**Notification of Exhibition for Section 96(2) Modification to Gosford Hospital
Redevelopment (SSD 6913)**

Thank you for your email message dated 13 September 2016, requesting Transport for NSW (TfNSW) review and comment on the above.

Figure 1: Diagram illustrating revised car park design

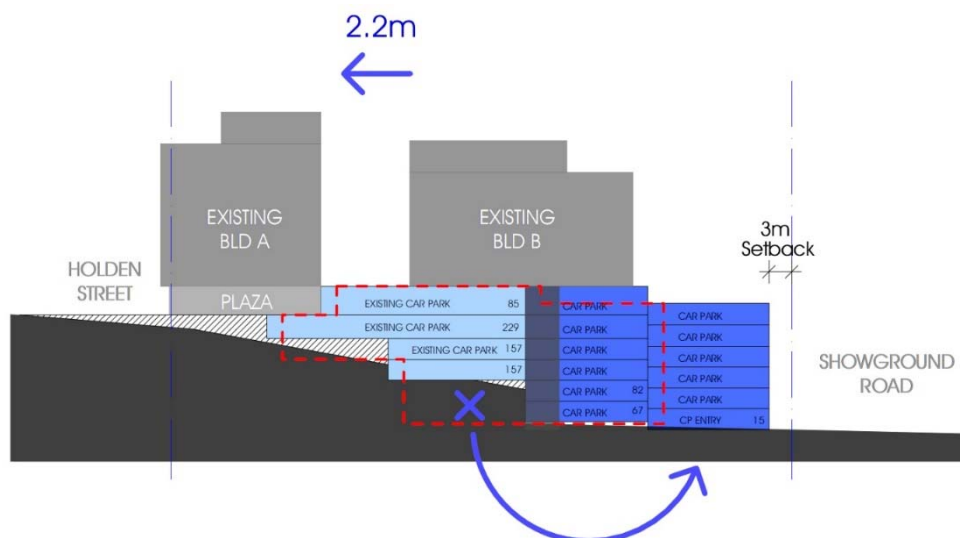
The modification proposal envisages changes to internal access arrangements to the car park and extension of the car park towards Showground Road. TfNSW requests that the applicant assesses the impacts and provide mitigation measures, in consultation with TfNSW and Central Coast Council, for the following as a result of the proposed changes:

- Future bus services and facilities (bus stops) along Showground Road; and
- Pedestrian facilities for all road users including mobility impaired pedestrians from future bus stops on Showground Road and the hospital entrance.
